Planning Application Ref: BN/66/19/PL

Location: Land off Canal Mews, Barnham, PO22 0DP

Description of works: Erection of 3 No dwellings

Mark Warwick
Tree Officer / Parks and Greenspace Team

Client Seaward Properties Ltd.			
Project Title and Location Land to the East of Barn Rise Barnham			
Drawing Title Tree Retention Protection Plan			
Scale 1:100@A1	Drawn LB	Approved JJ	Date 24.07.19
Drawing No LLD1345-ARB-DWG-002	Revision 01

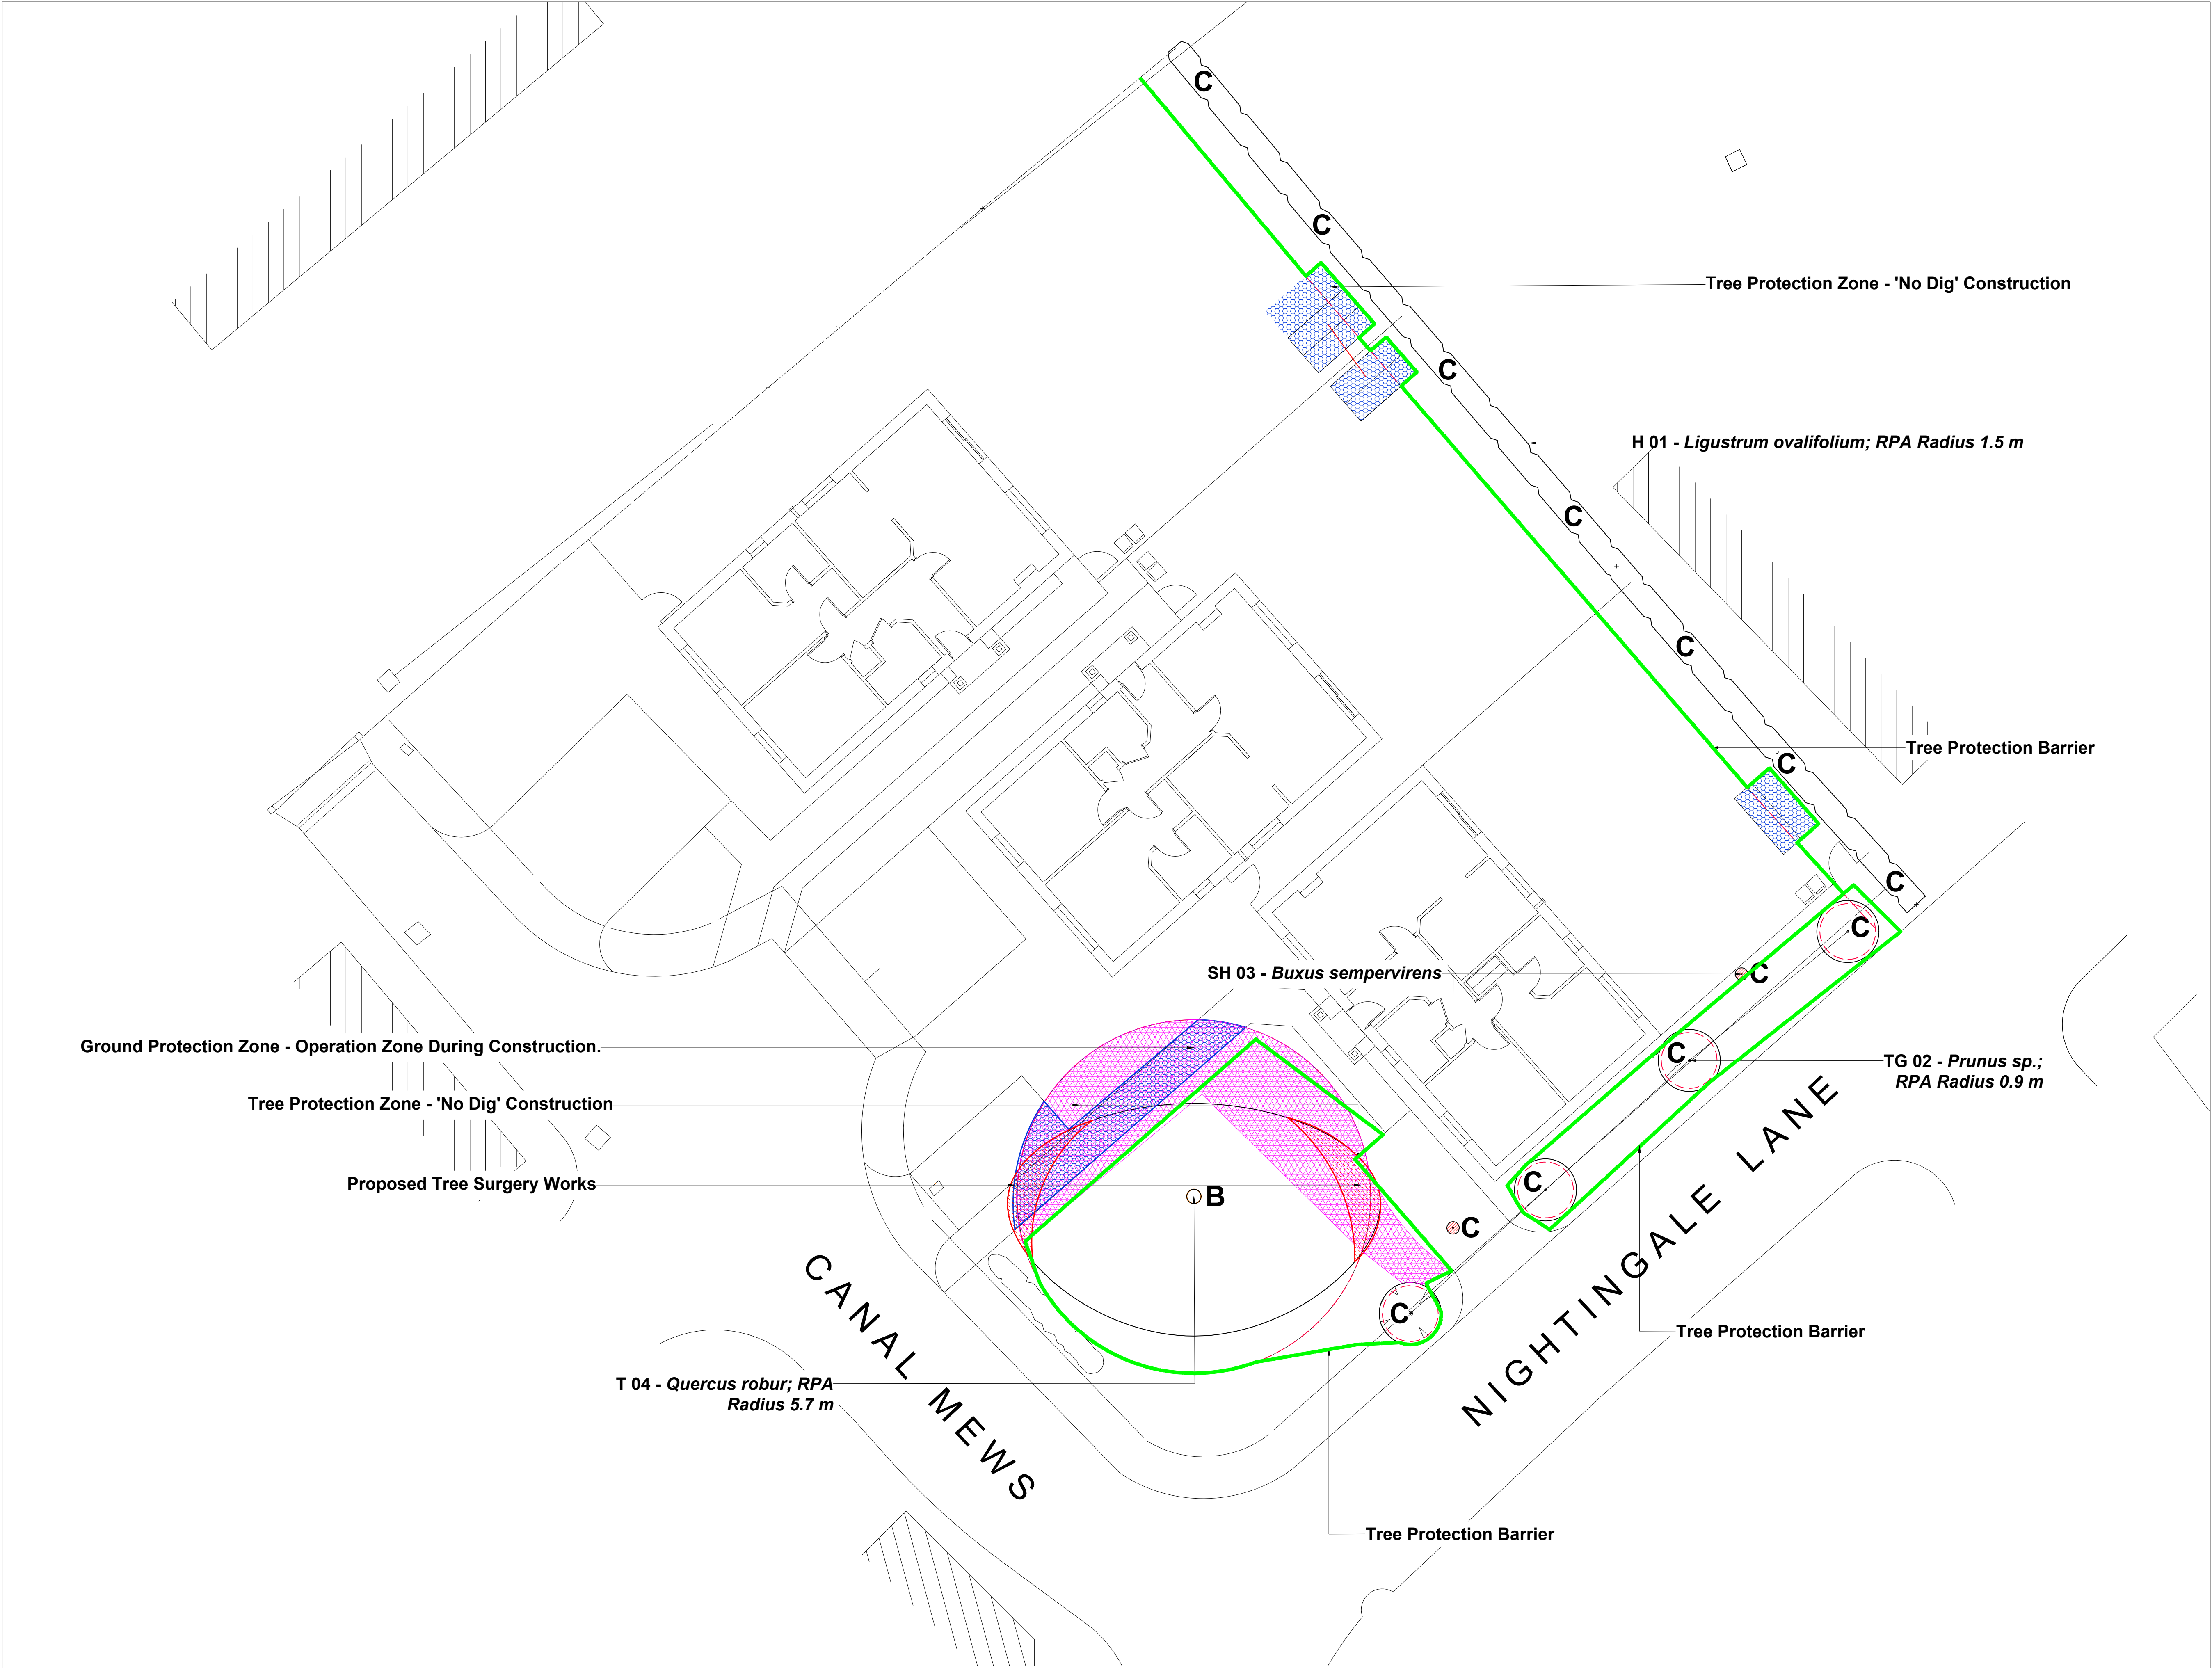
- The current proposed layout is going to impact heavily on the only significant tree (T04 – oak), both above and below ground. Although achievable in principle by adopting the tree protection measures proposed; there is nonetheless a risk that attaches during such incursion of root protection areas (RPAs). This is especially significant where the tree in question is so prominent, of current high public amenity value, long-term potential and has endured recent ground disturbance/amelioration on remaining aspects.

- The applicant has submitted a revised site layout plan, dwg. no. 1705-12. This illustrates avoidance of RPA incursion which is a welcome advance on the previous layout. That said, construction in the form of vehicle parking bays is proposed on two aspects and tight against the RPA perimeter. The practicality of working so close means that were we to approve that layout, some RPA incursion would have to occur. Of greater significance, is the effective containment of the tree by inhibiting future root growth. Both these important areas of conflict have been resolved with the submission of an improved Site Layout plan, dwg. no. 1705-12H

- I recommend this scheme for **APPROVAL**, subject to the following conditions being applied:
1. Before the site is occupied or any machinery is introduced to the site or demolition work or construction work or alterations to existing ground levels takes place a **PRE-COMMENCEMENT Site Meeting** is to take place between the Planning Authority's Tree Officer and the Arboricultural Expert representing the site owner(s) – at this meeting all protective fencing will be inspected to verify it is 'Fit for Purpose' as required under British Standard 5837:2012 and have been erected and positioned exactly as shown on the **Tree Retention Protection Plan, dwg.LLD1345-ARB-DWG-002, Rev 02**.
